APPENDIX D – ENGAGEMENT SUMMARY TABLE

Drawing Title
EAST ELEVATION

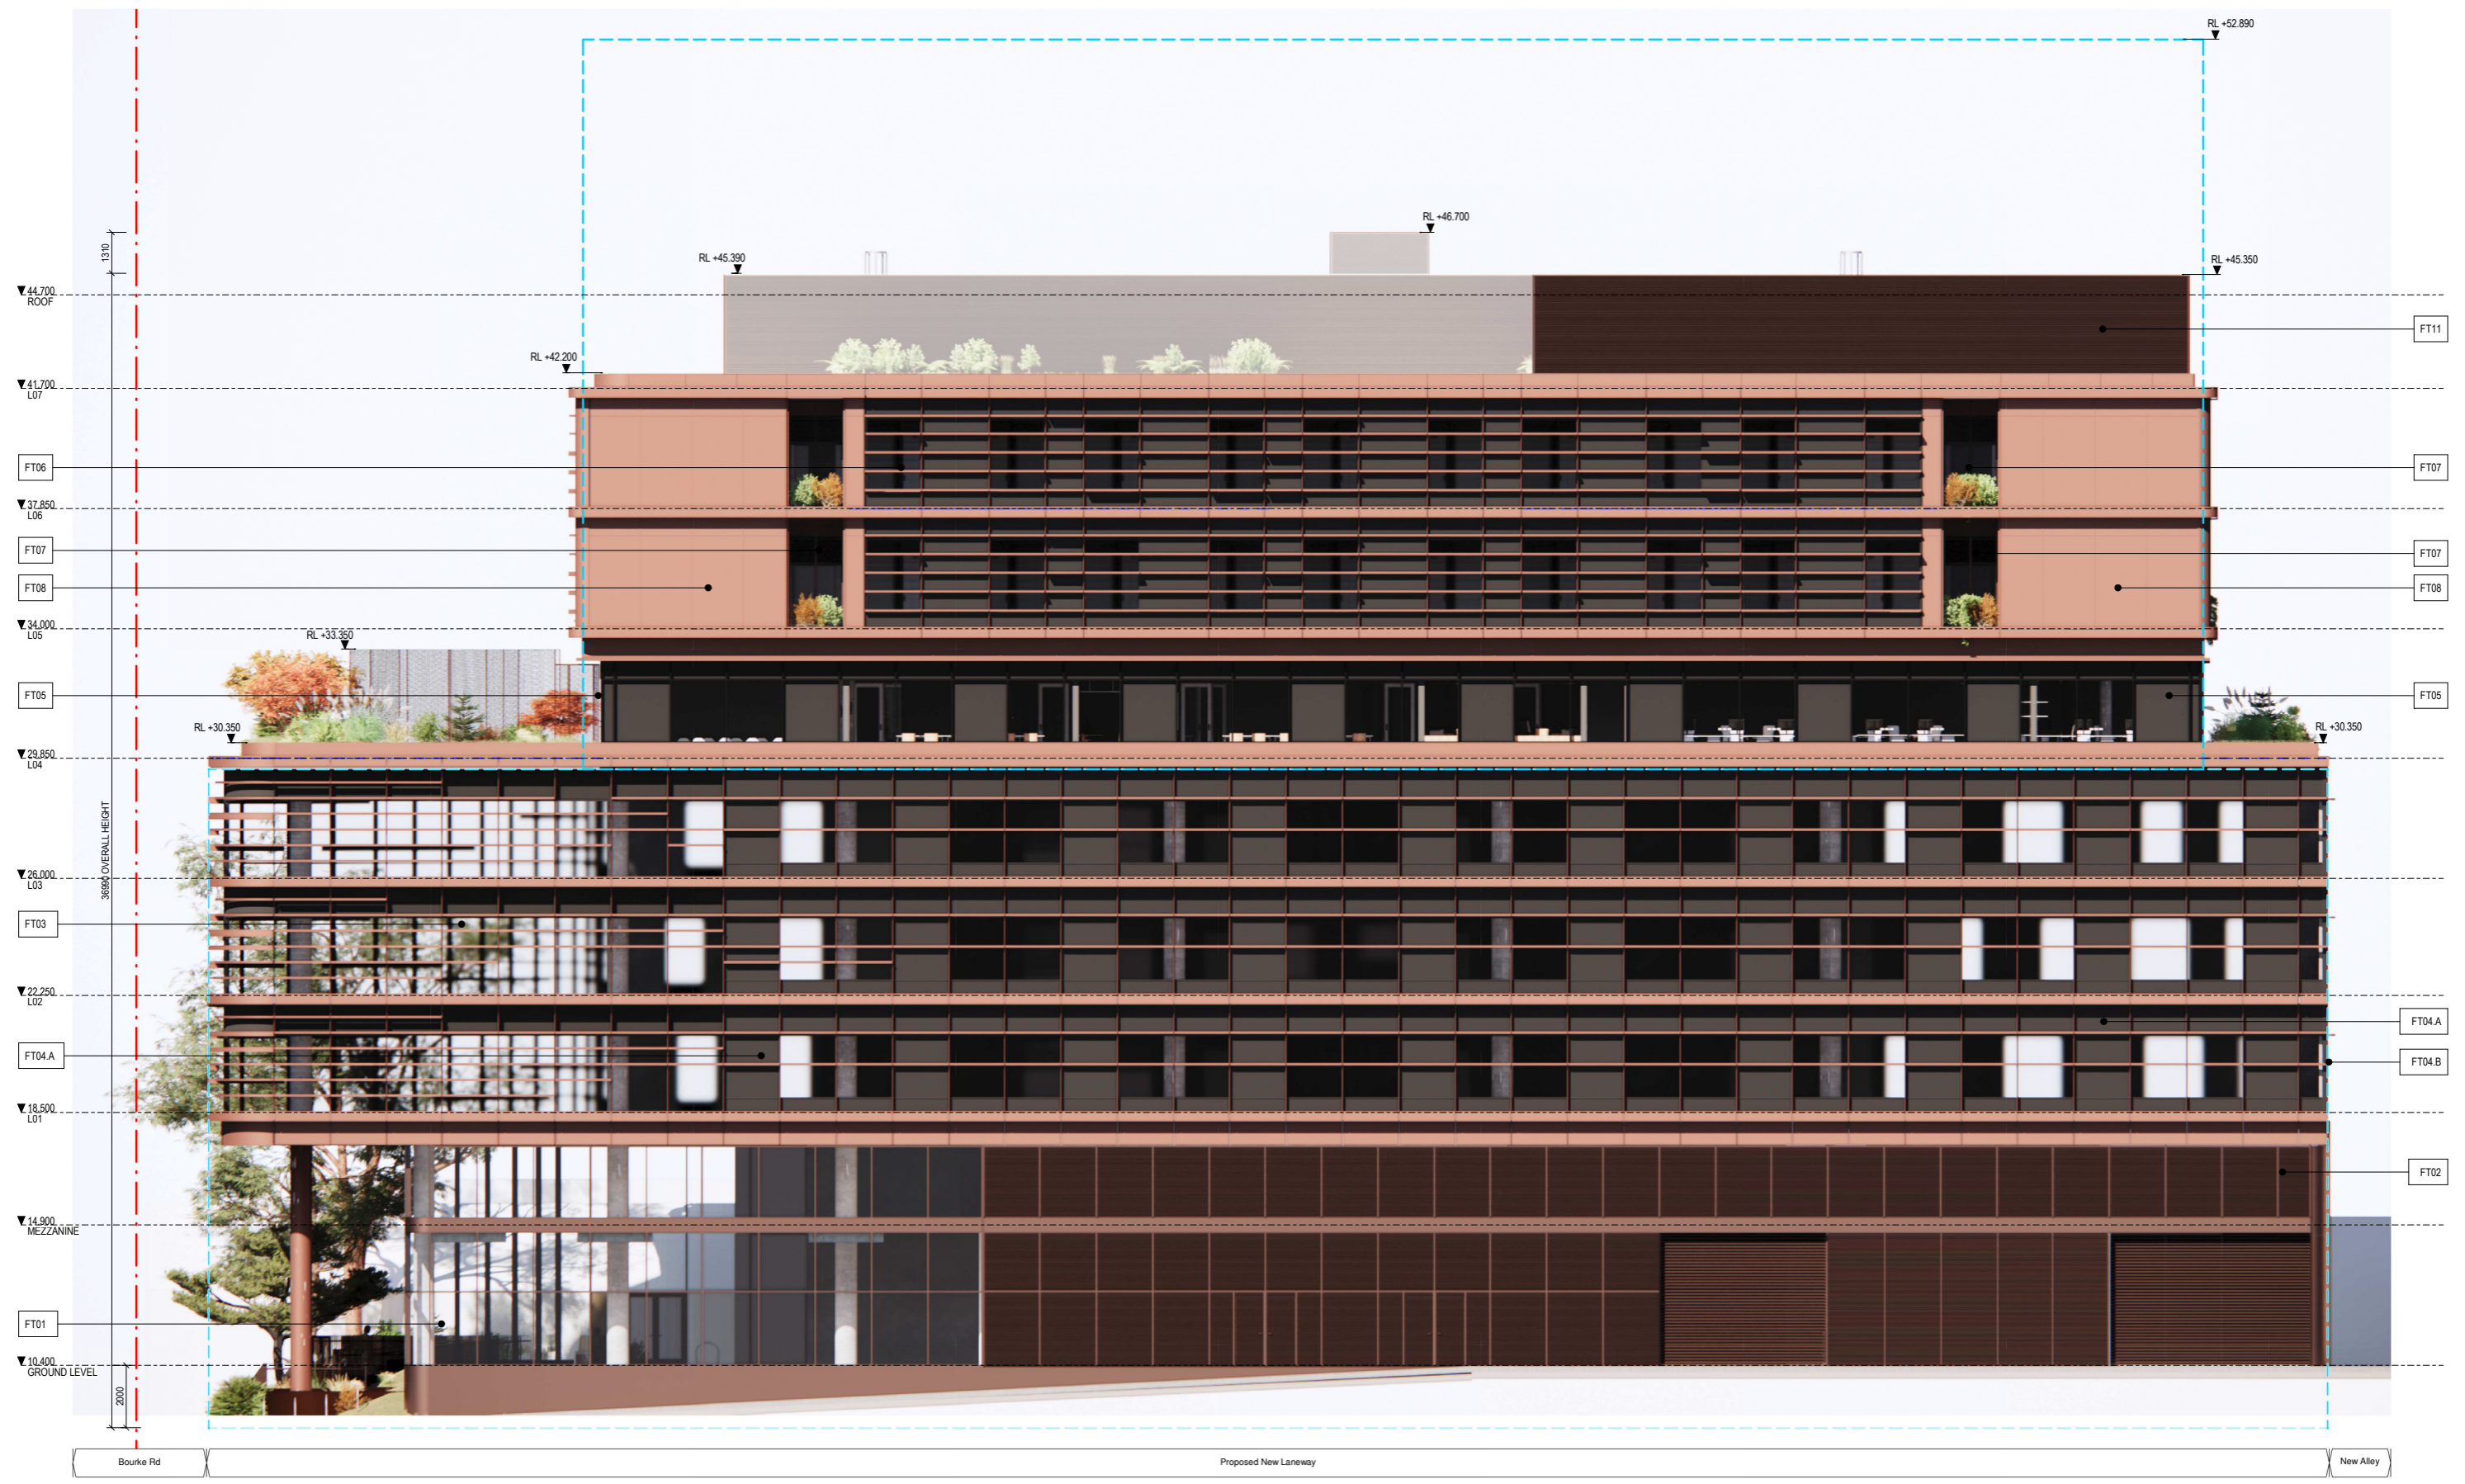
<p><i>Floor Plates and Natural Light</i></p> <p>The panel noted that the deep floor plates and the natural light available to</p>	<p>Warren and Mahoney + MAAP included additional windows along the eastern boundary</p>

Stakeholder	How this group was consulted	Feedback	Project response
		<p>the lower levels still needed more consideration.</p> <p>More consideration of how light and solar access could be pulled down into the building.</p>	<p>to provide additional light into the lower levels 1-3.</p>
		<p><i>Façade design</i></p> <p>The panel queries the number of solid elements within the Level 4 façade cladding and the façade treatment. They also queried the depth of the recess on Level 4 noting that the intended shadow gap separation between and the top and the bottom halves of the building was not being achieved.</p> <p>The panel queried access and maintenance arrangement for the planters integrated into the façade.</p> <p>The panel expressed a preference for a patterned eastern elevation as opposed to public art due to the proposed multi-storey development at the neighbouring site.</p>	<p>Warren and Mahoney + MAAP noted that a certain amount of solid cladding would be required along the Level 4 façade given the operational requirements of the hospital and patient accommodation.</p> <p>Warren and Mahoney + MAAP added a pattern which provides façade relief to the relatively blank façade.</p>
